From: Contact Centre (CRM) <contact@ribblevalley.gov.uk>
Sent: 27 April 2026 20:34
To: Planning
Subject: Planning Application Comments - 3/2026/0242 FS-Case-832495636

Planning Application Reference No.: 3/2026/0242

Address of Development: 31 Castle View Clitheroe BB7 2DT

Comments: The only aspect of the proposed development at 31 Castle View would like to comment on is the design of the utility room roof on extension No.2 -

Proposed Ground Floor - 1:50

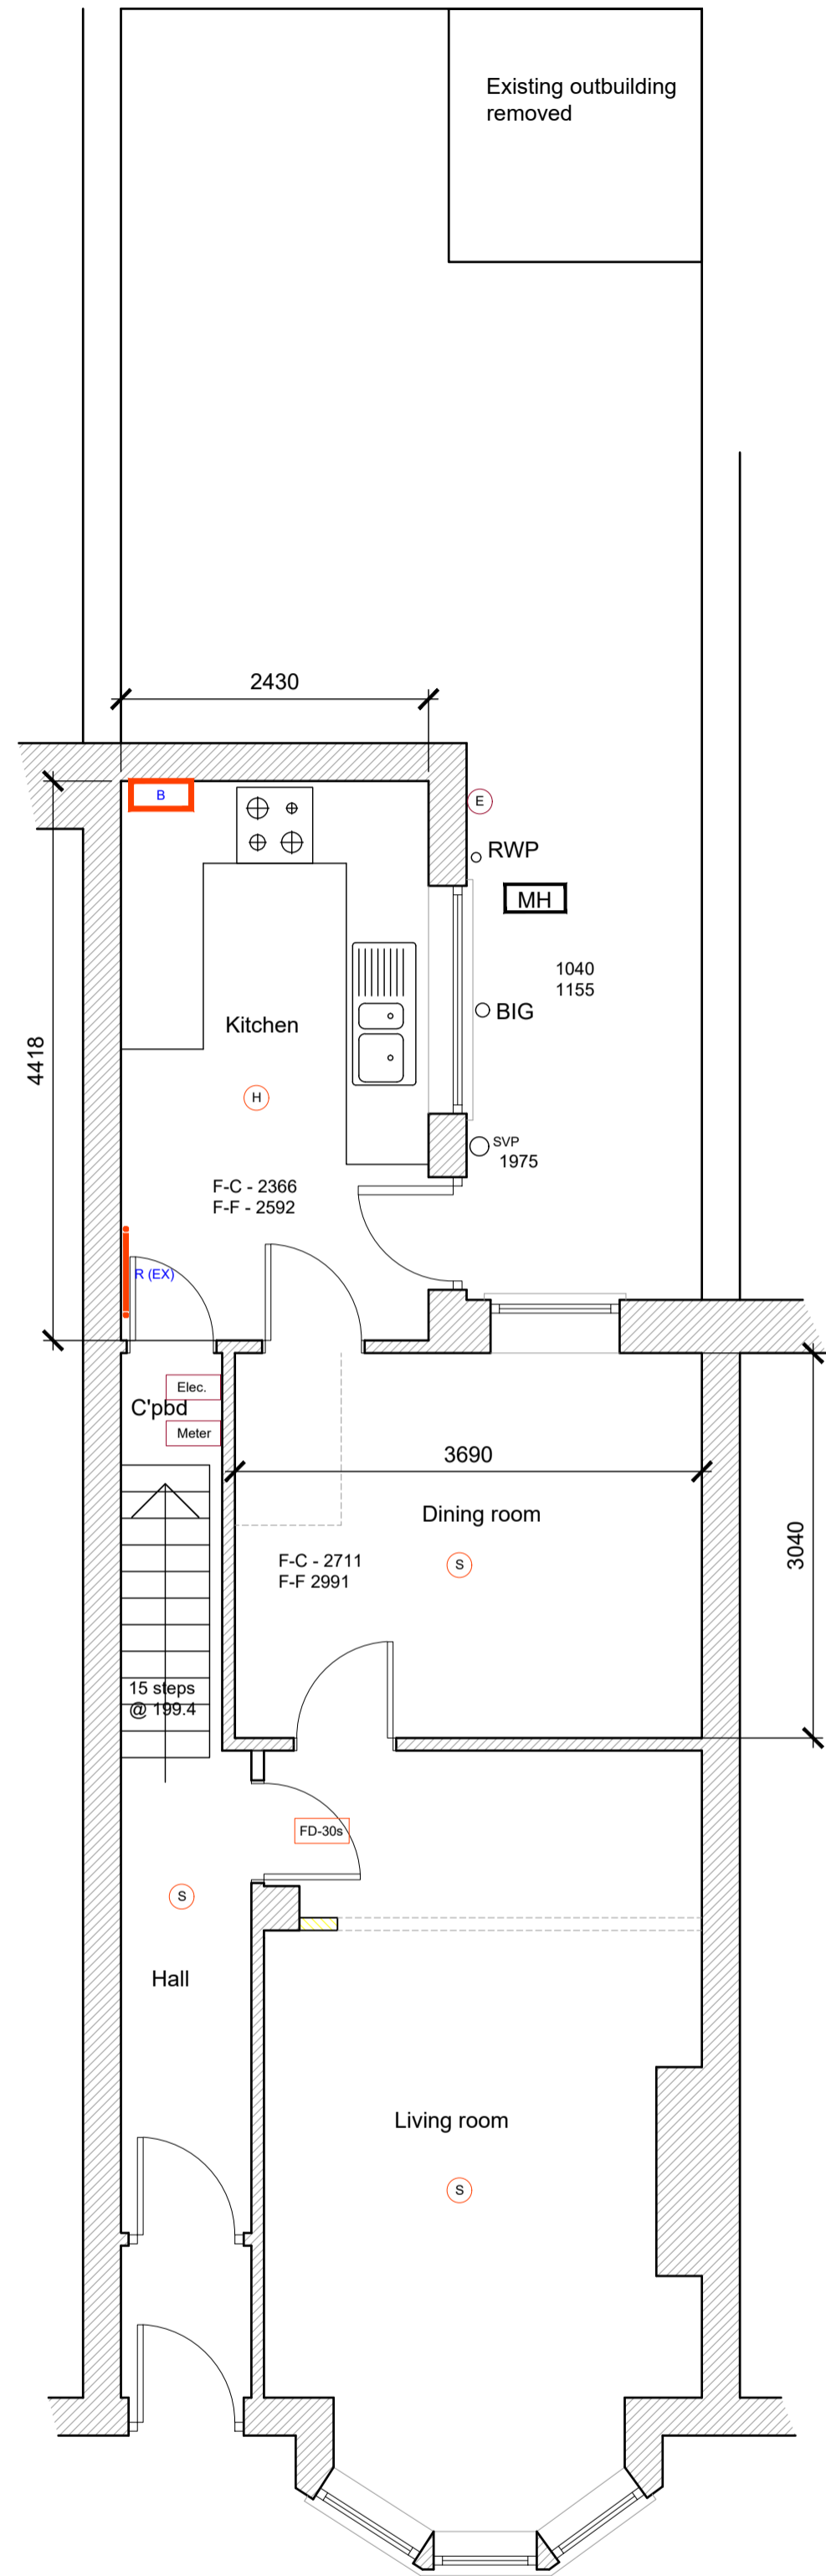
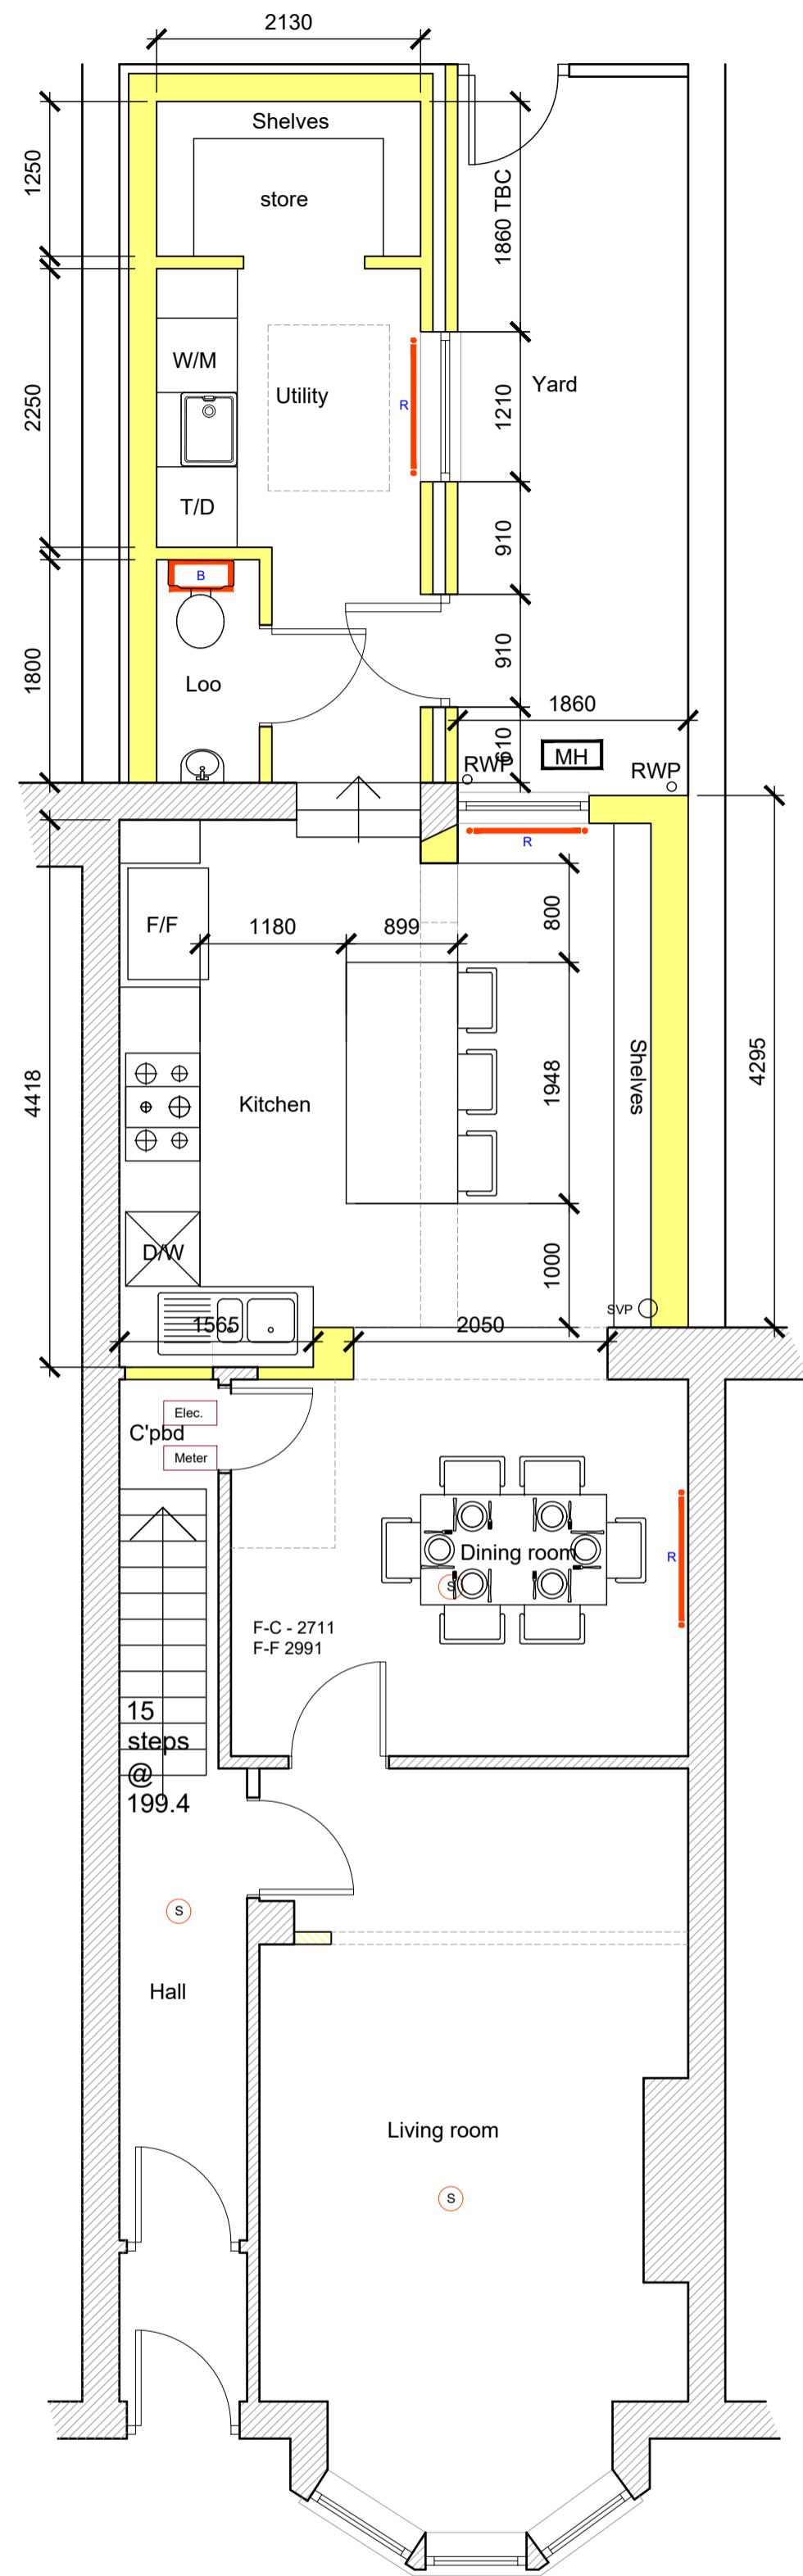
I assume the installation of a hopper and downpipe at the rear of No.29/31 will be in the backstreet connecting to the main sewer ? This is illustrated on the end elevation but not the plan or the North elevation, nor is there any mention of an RWP at the end of extension No.2 ?

Proposed West Elevation - 1:100

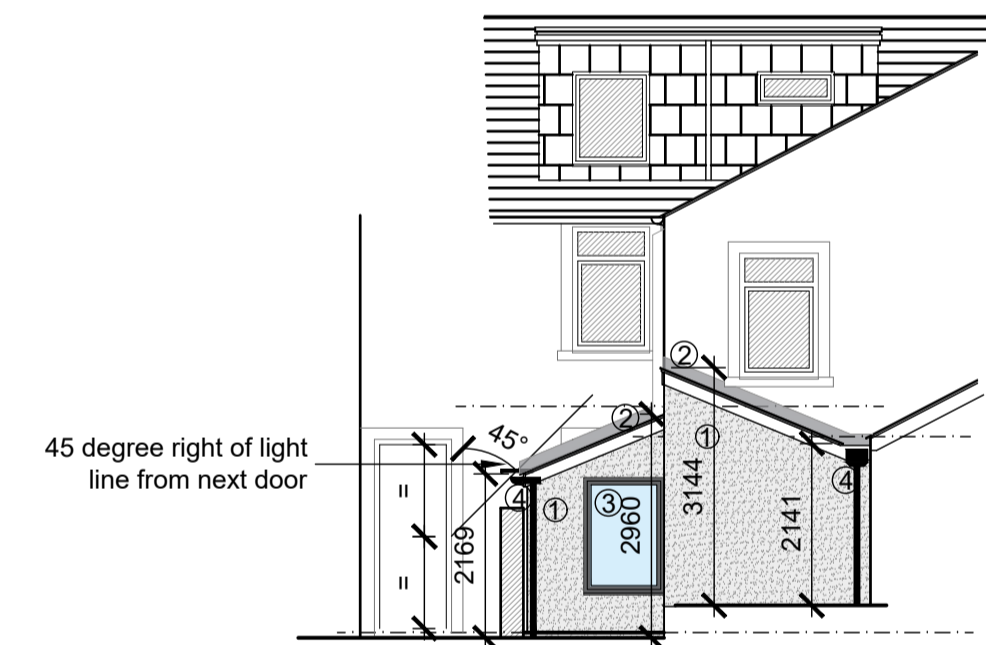
1. The angle of extension No.2`s roof is very acute producing an imposing 3144mm (10`3") wall.
2. As can be clearly seen from the drawing, owing to the topography of the adjoining properties at the rear of the buildings. [REDACTED] The 3144mm wall will appear to be (approx) some 3.8 – 4m from No.33`s, kitchen, utility room and yard (again, owing to the topography of Castle View the [REDACTED]`s producing an even higher visual effect at that end). I feel this will produce a very imposing unattractive wall.

3. The proposed wall will bring about considerable light restriction to [REDACTED], especially in the kitchen and utility room, also the outdoor space.

4. This wall will have a detrimental effect on the view and sense of [REDACTED] from both inside and outside the property.
5. Many similar projects have been undertaken locally over the years in a more sympathetic manner. The proposed addition could be seen as not in keeping with the surrounding area. (Pitched slate or flat rooves predominate locally).

Looking at the design of No.2 extensions roof, it maximises light in the utility room at No.31 at unfortunately, the expense of light inside the kitchen and utility room and yard of [REDACTED]
